PROJECT TITLE: Concrete Systems ZONE ATLAS/DRNG, FILE#: H-16/10107
DRB #: _____ EPC #: _____ WORK ORDER #: _____
LEGAL DESCRIPTION: Tract A, Block D, Duke City Industrial Addition
CITY ADDRESS: 3120 Richmond NE

**RE: CONCRETE SYSTEMS (H16-D107) ENGINEER'S CERTIFICATION FOR
CERTIFICATE OF OCCUPANCY. ENGINEER'S CERTIFICATION STAMP
DATED 8-9-95.**

RE: REVISED DRAINAGE PLAN FOR CONCRETE SYSTEMS (H16-D107)
REVISION DATED 10/26/94.

RE: DRAINAGE PLAN FOR CONCRETE SYSTEMS (H16-D107) ENGINEER'S
STAMP DATED 10/17/94.

SHEET C1 OF 1

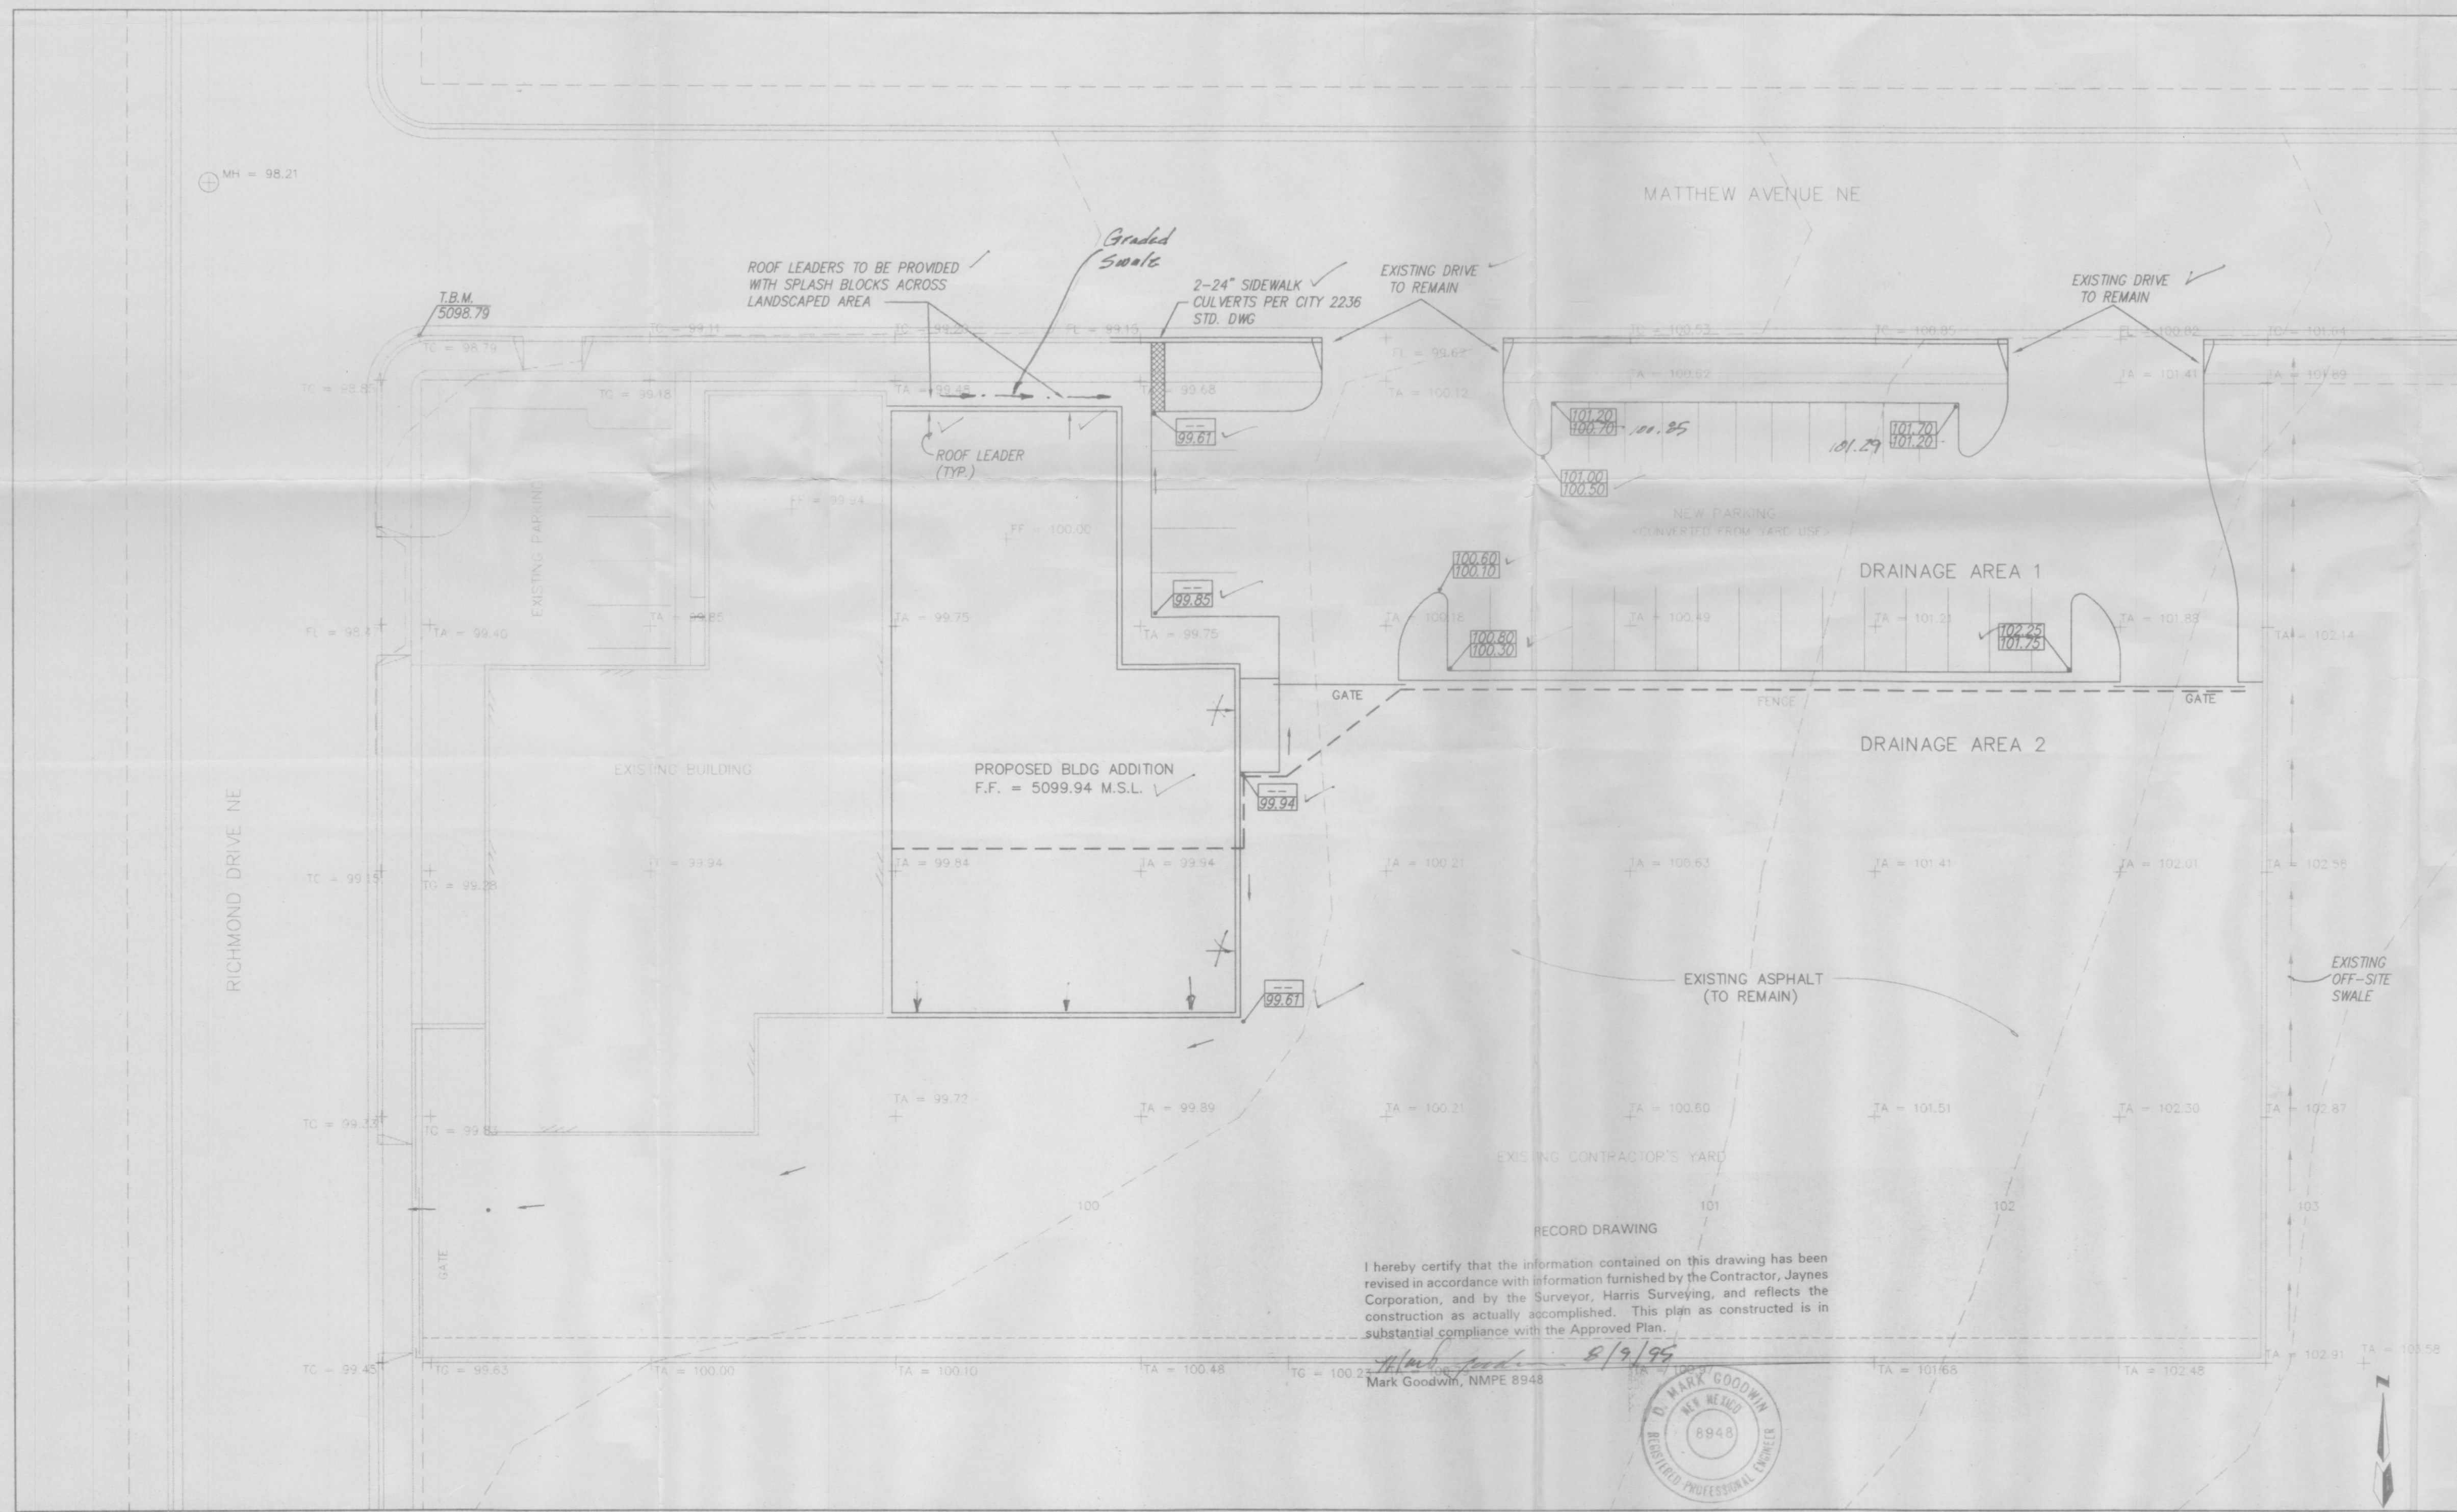
- ✓ 1. T.B.M. must be permanently marked by a curb notch or painted.
2. Roof leader on the north side of building must be extended onto the asphalt area.
3. Entrance capacity of the proposed sidewalk culverts.
4. Two copies of plan at resubmittal.

SHEET C1 OF 1

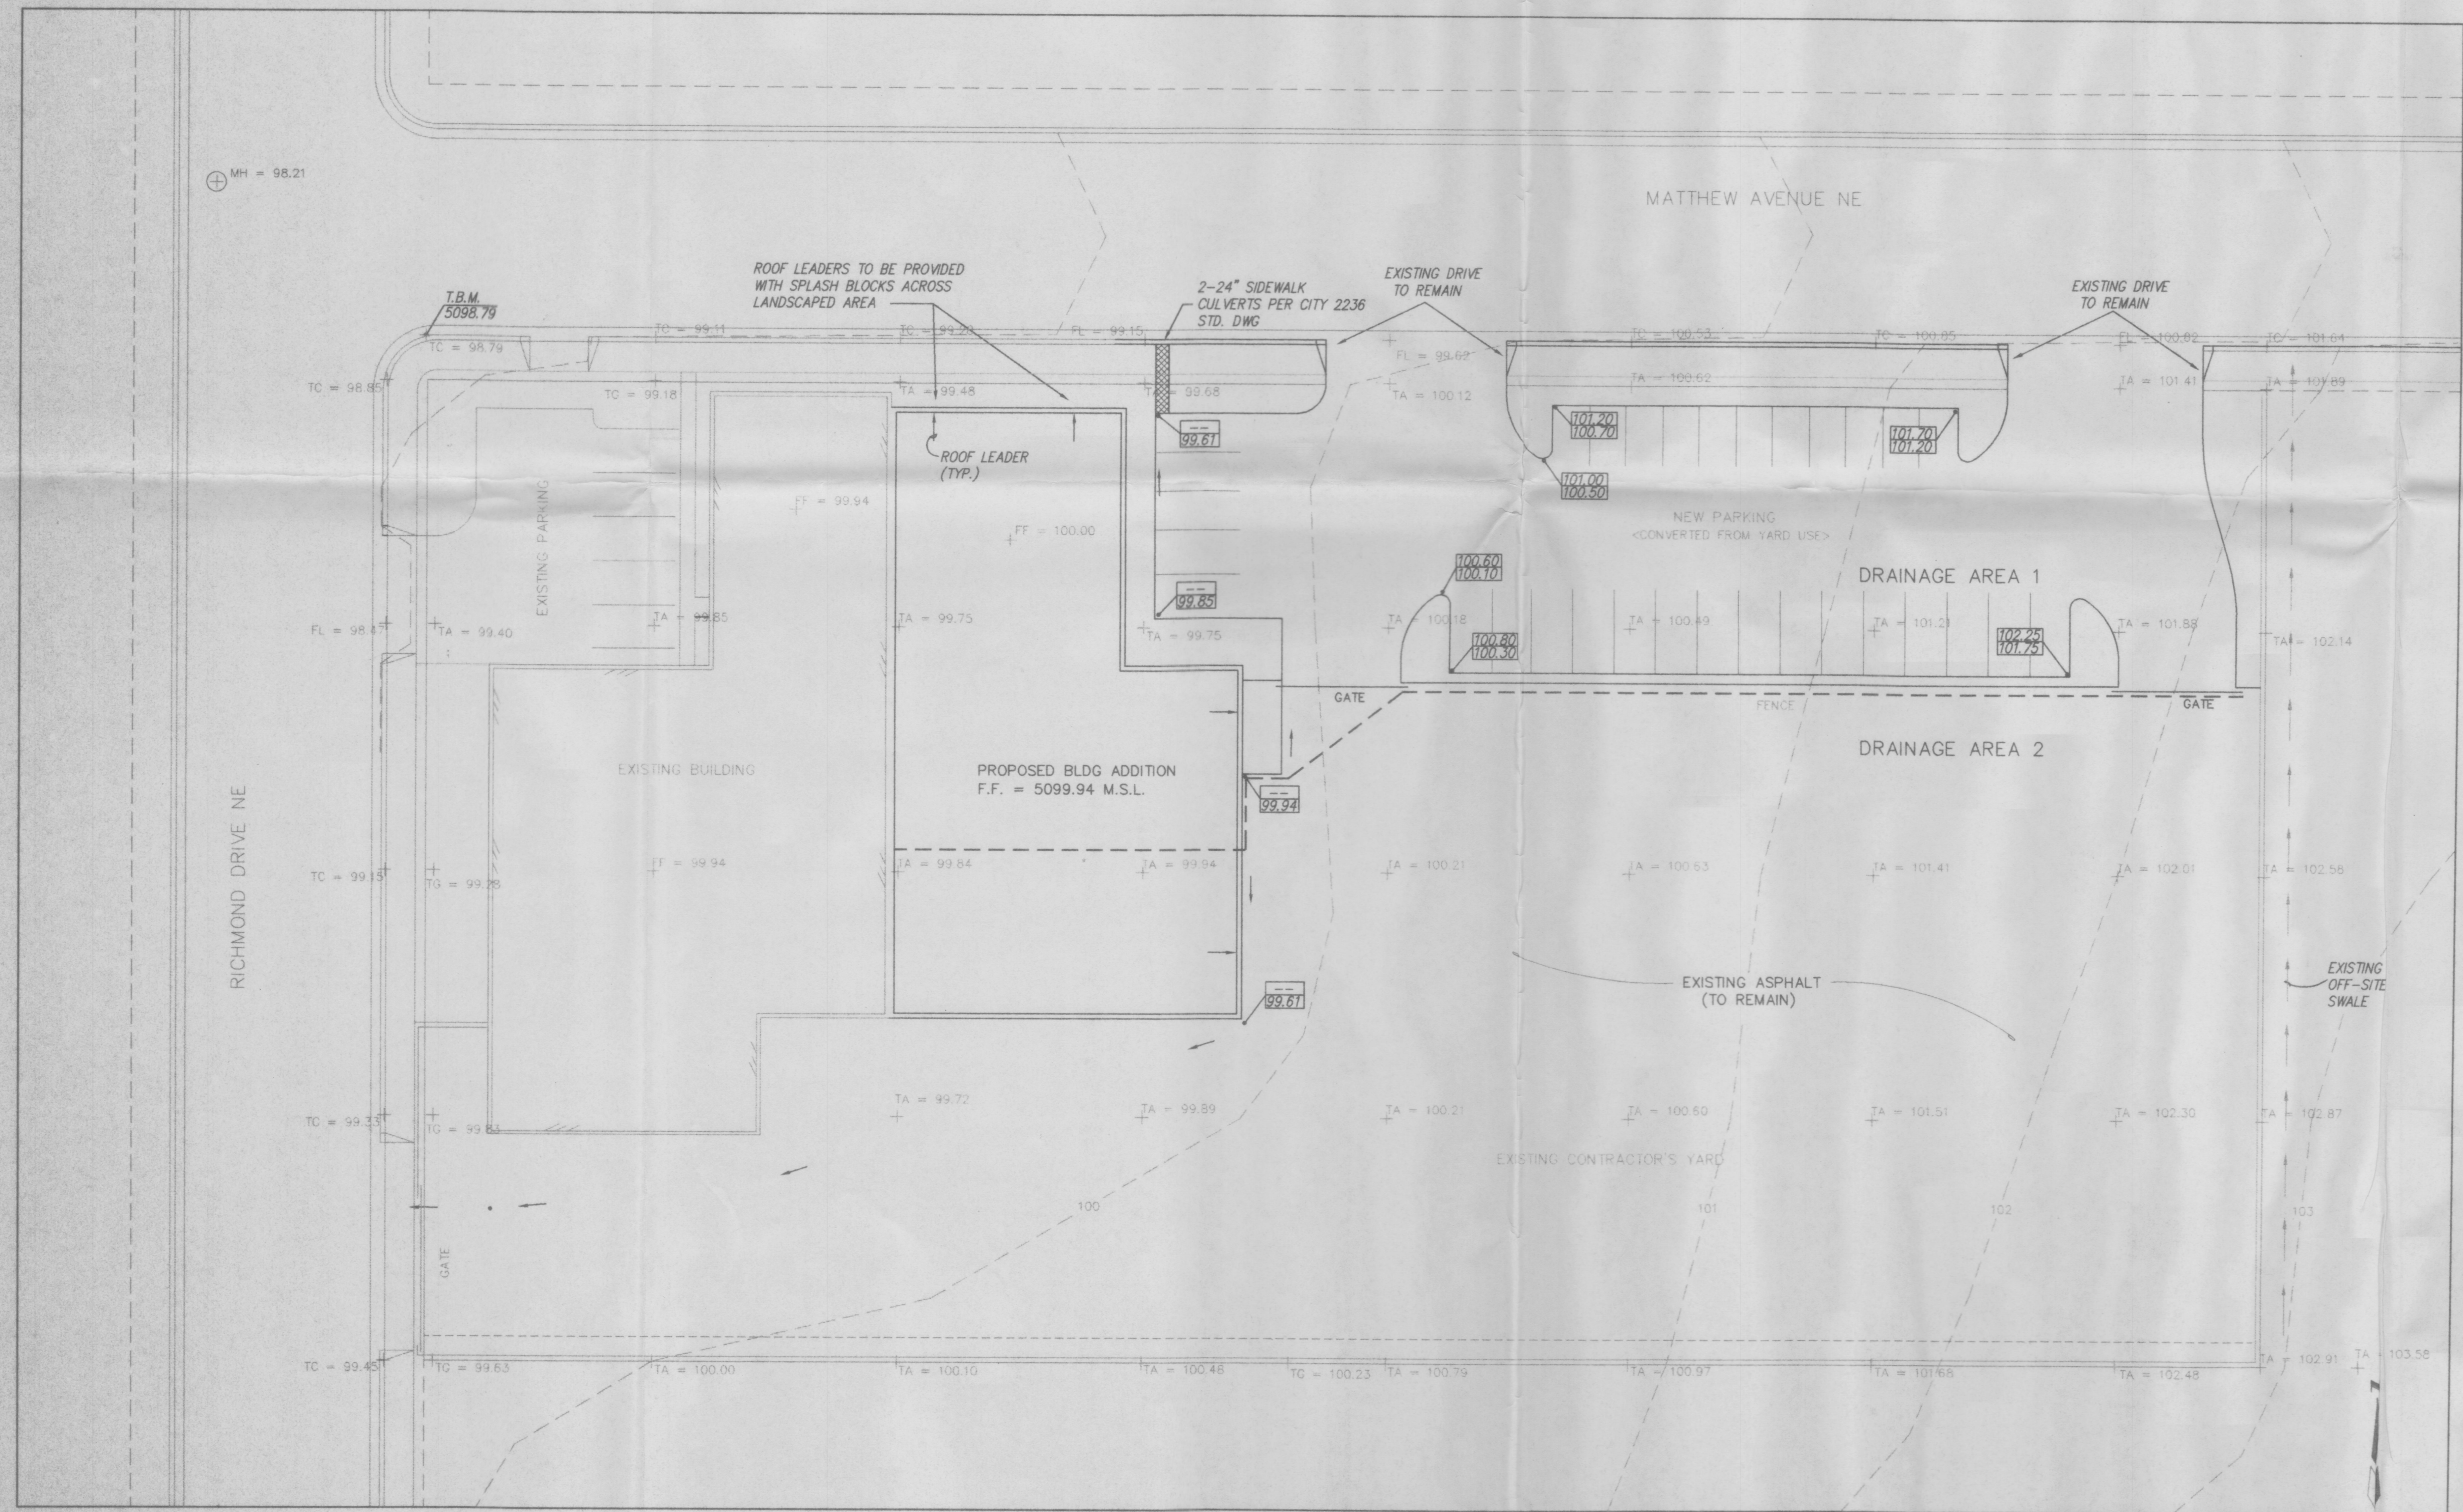
Please be advised that the roof run-off on the north side of the proposed addition must be routed to the proposed sidewalk culverts. No developed run-off is allowed to cross the public sidewalk or curb & gutter.
